**CITY OF ALBUQUERQUE
PLANNING DEPARTMENT
April 11, 2007
DRB Comments**

PROJECT # 1005365

APPLICATION # 07-00403

RE: Tract 300- A-2- B-1,MRGCD Map 38, tbka Lands of Lopez & Padilla/plat

PLAT OF
 LOTS A, B & C
 LANDS OF LOPEZ & PADILLA
 Projected Section 13, T10N, R2E, NMPM
 within the Town of Albuquerque Grant
 City of Albuquerque
 Bernalillo County, New Mexico
 March, 2007

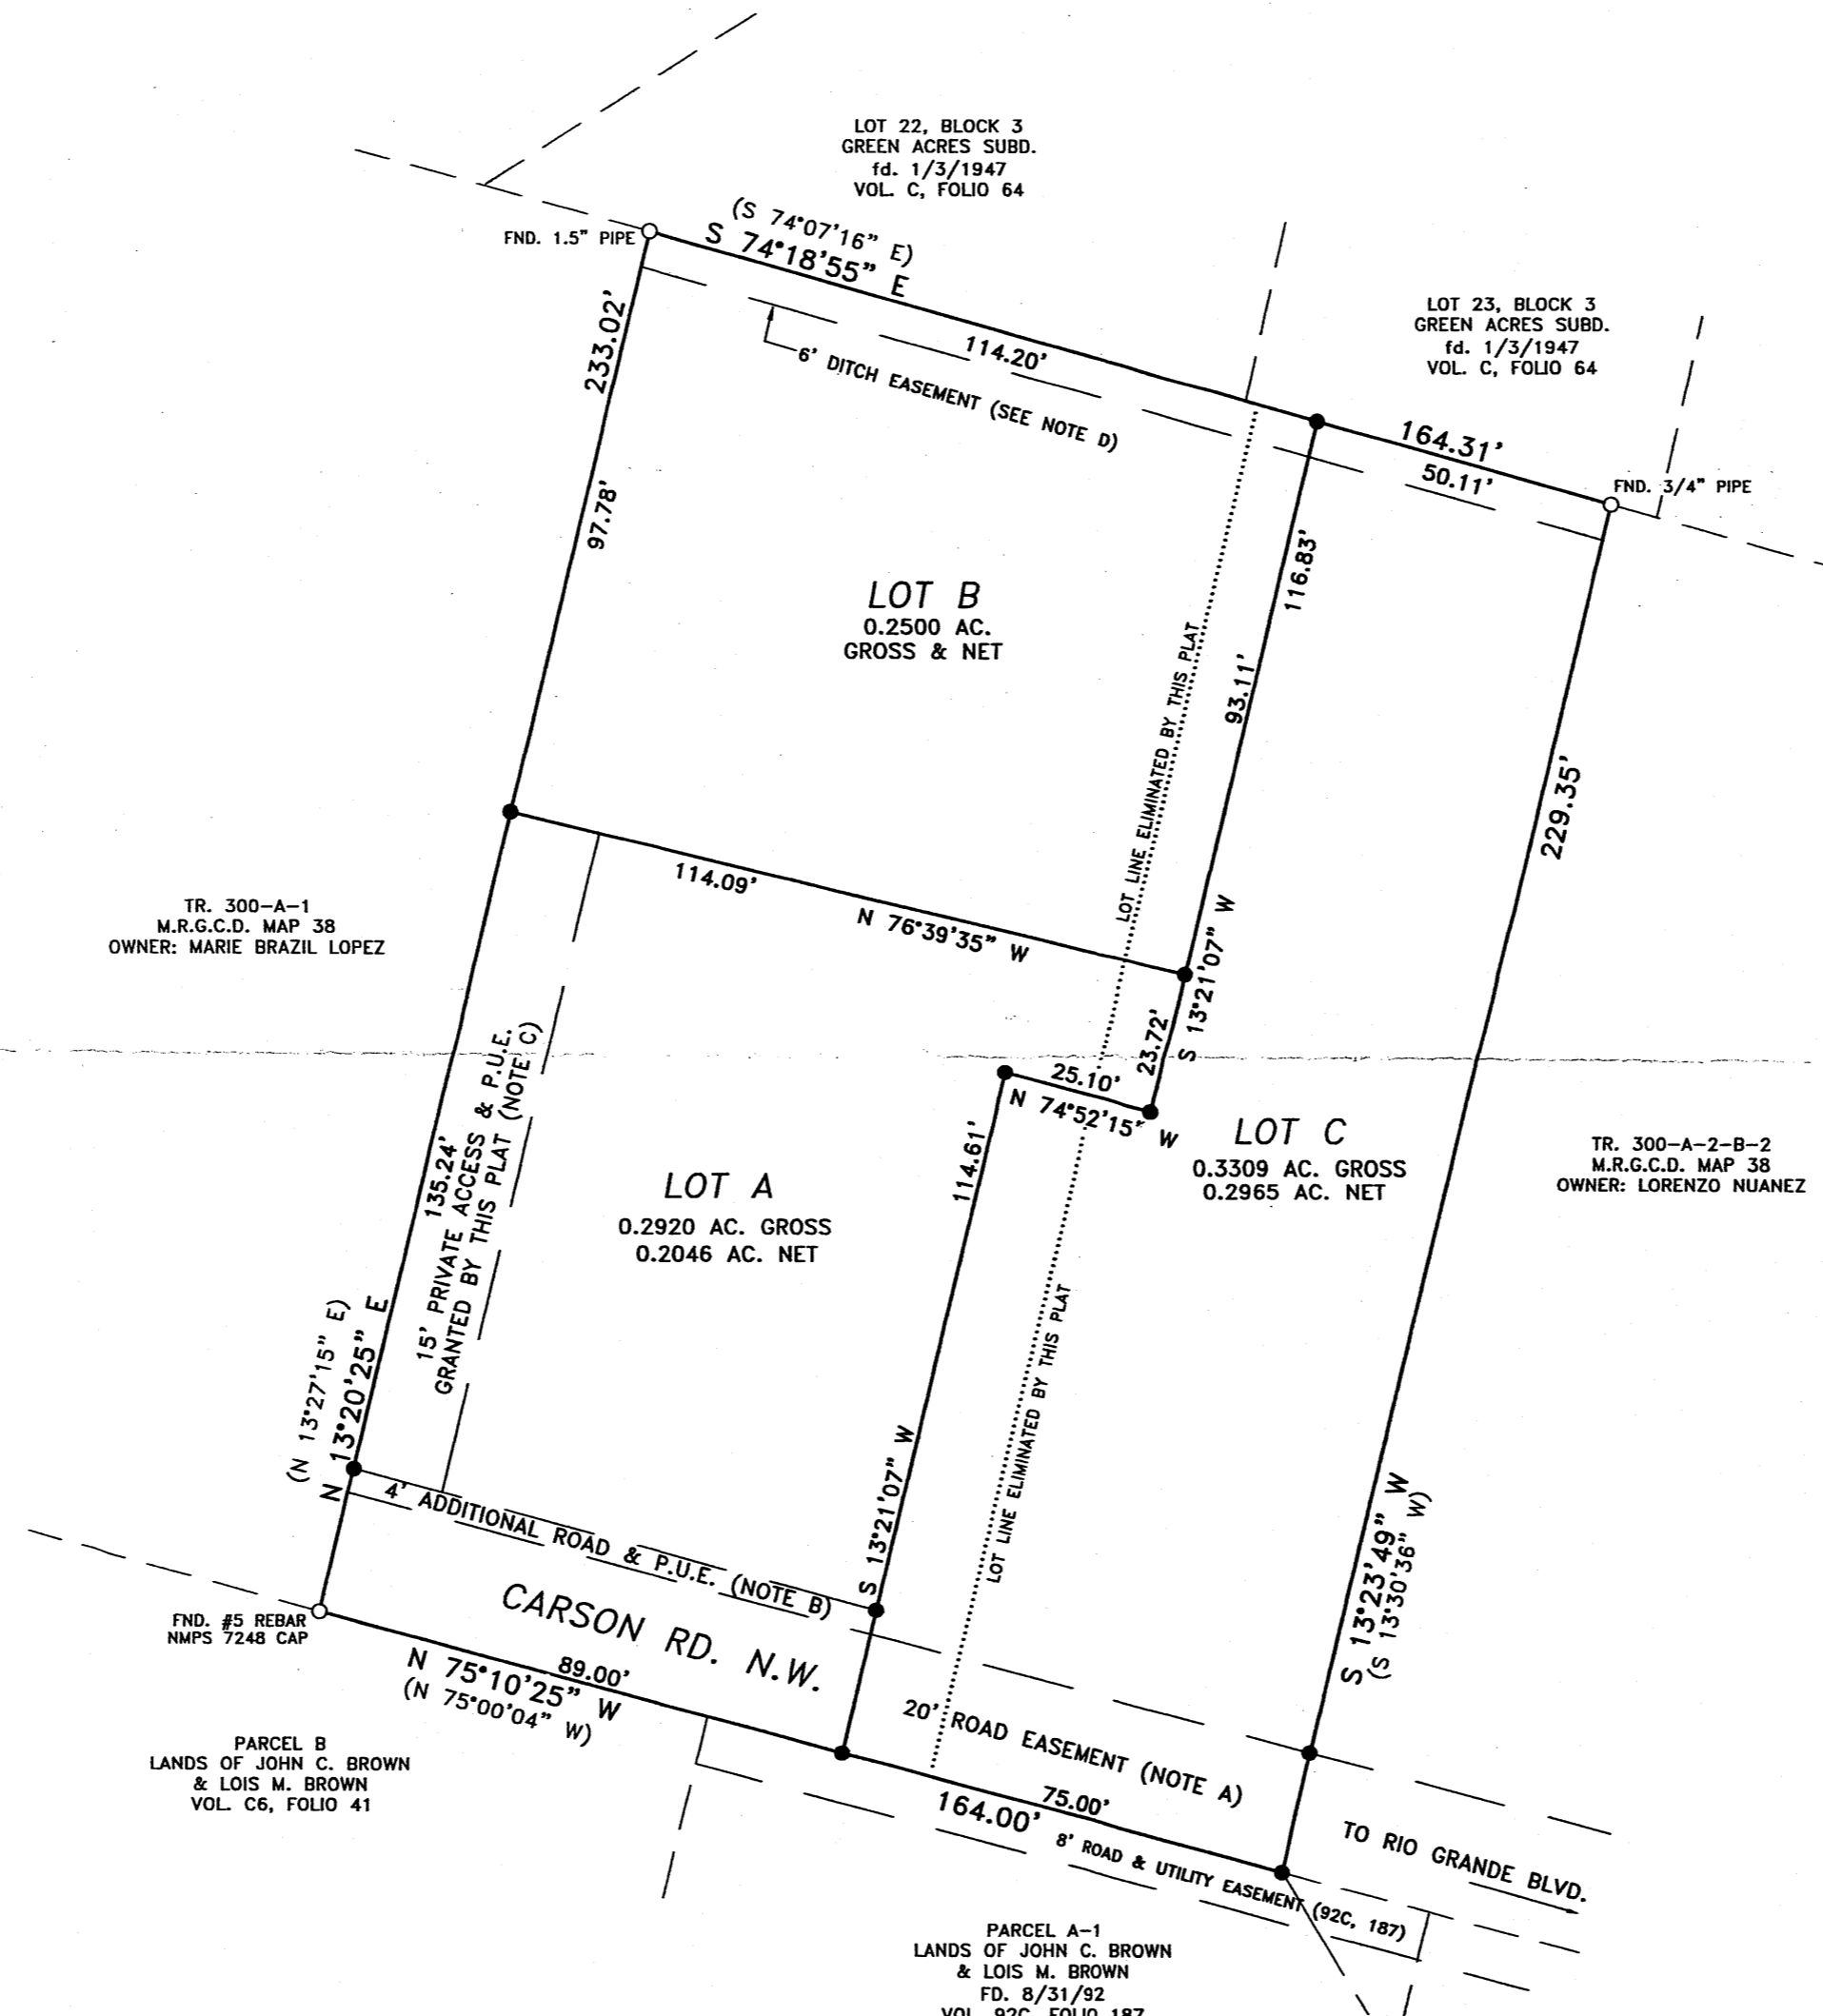
However, Lot A on the proposed plat does not meet the required 10,890 square foot requirement for RA-2 zoned property. The definition of "lot area" in the City Zoning Code does not permit the inclusion of private easements in the calculation of lot square footage. Agent was called on 4/06/07.
